RE: 68 Commercial Street BP#2015-01114 plan review comments

The following are responses to your comments regarding the Code Analysis found on A1.01- Life Safety Plans for the Maine Wharf Interior Fit-Up for the Portland Science Center.

2 | THIRD FLOOR STAIR PLAN  
SCALE: 1/4"=1'-0"

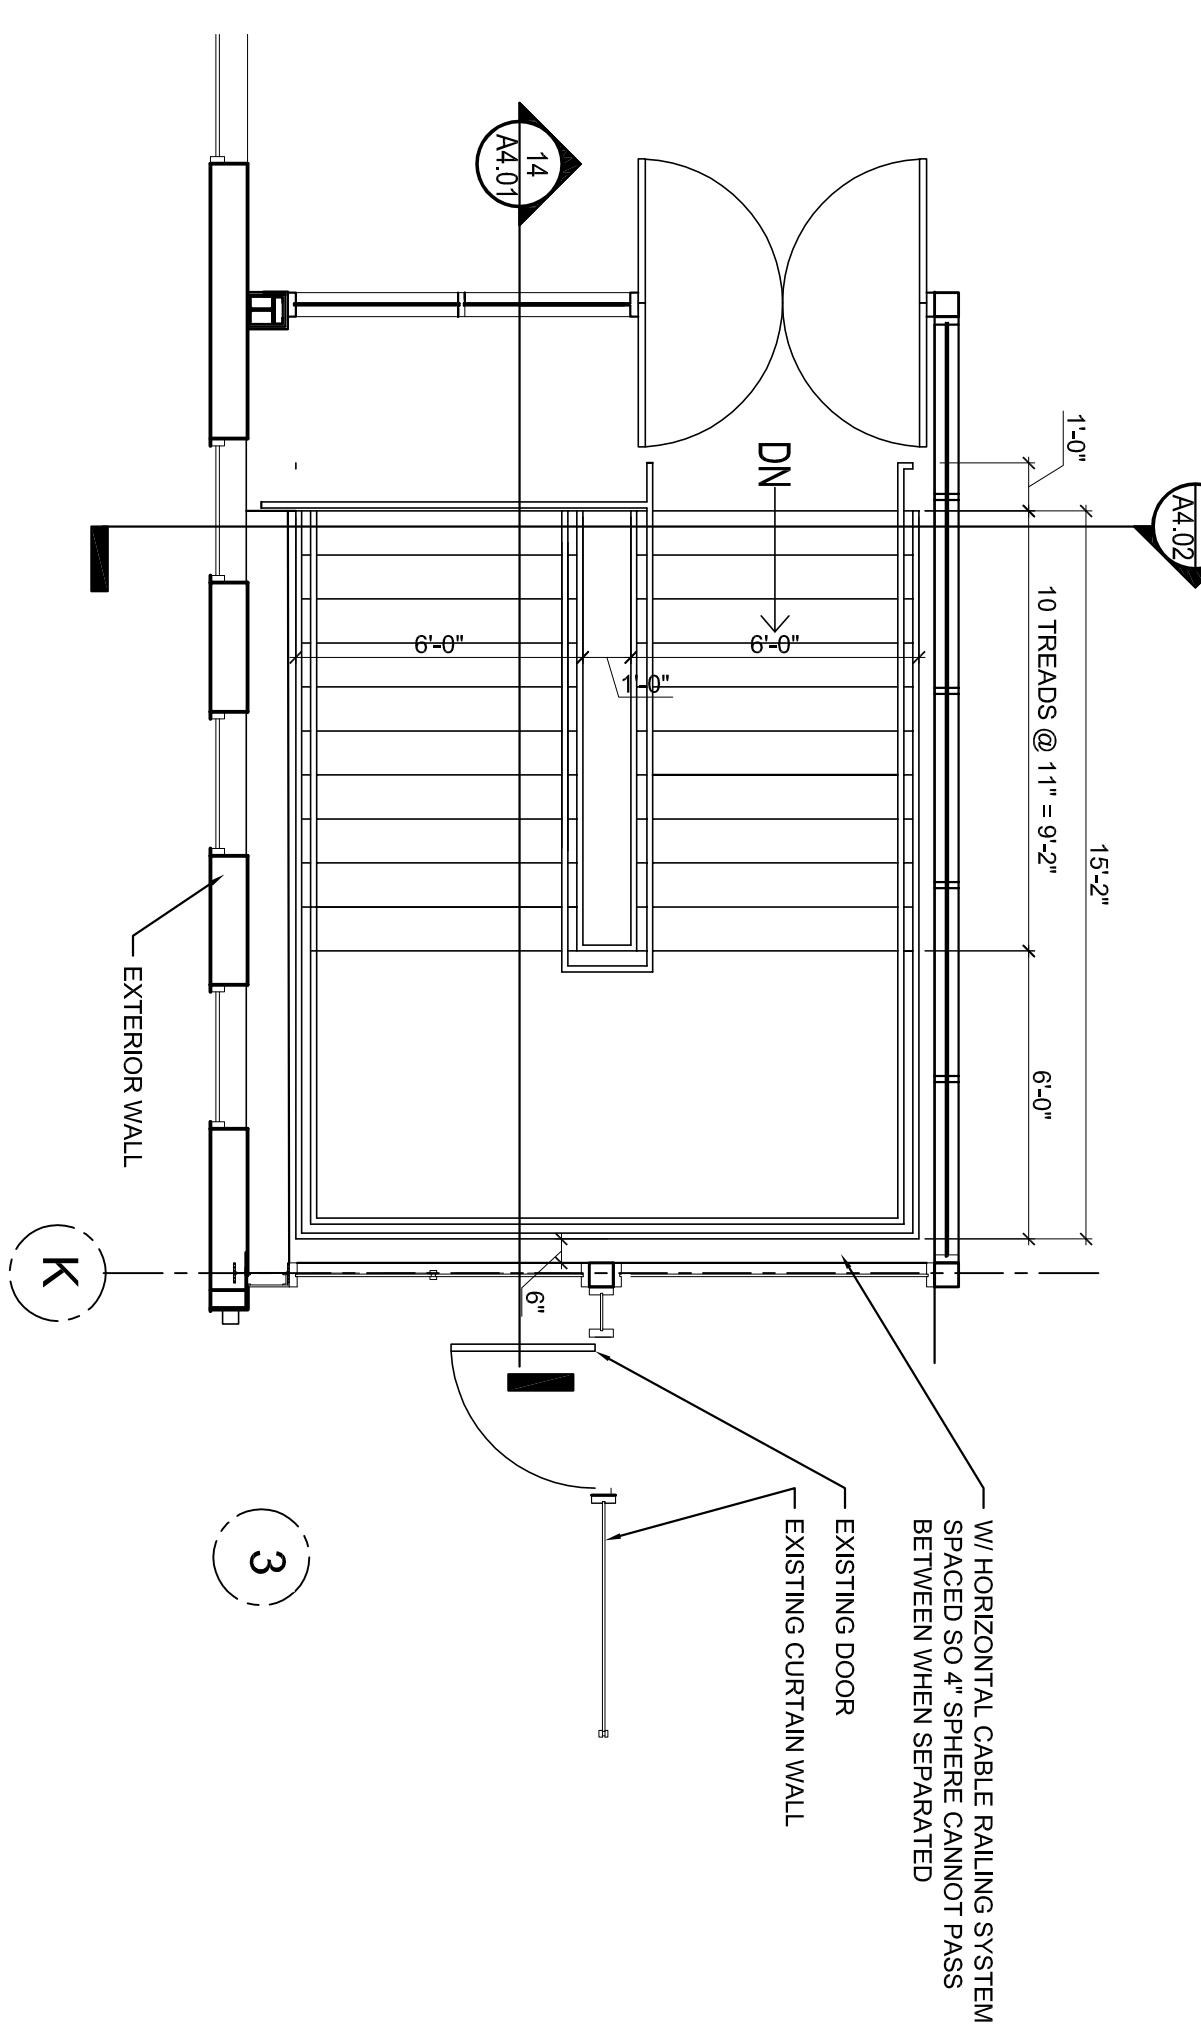
-The open stair connecting the second to the third floor is being proposed as an exit access stair. Because it has a clear width of 60", no intermediate rail is required.
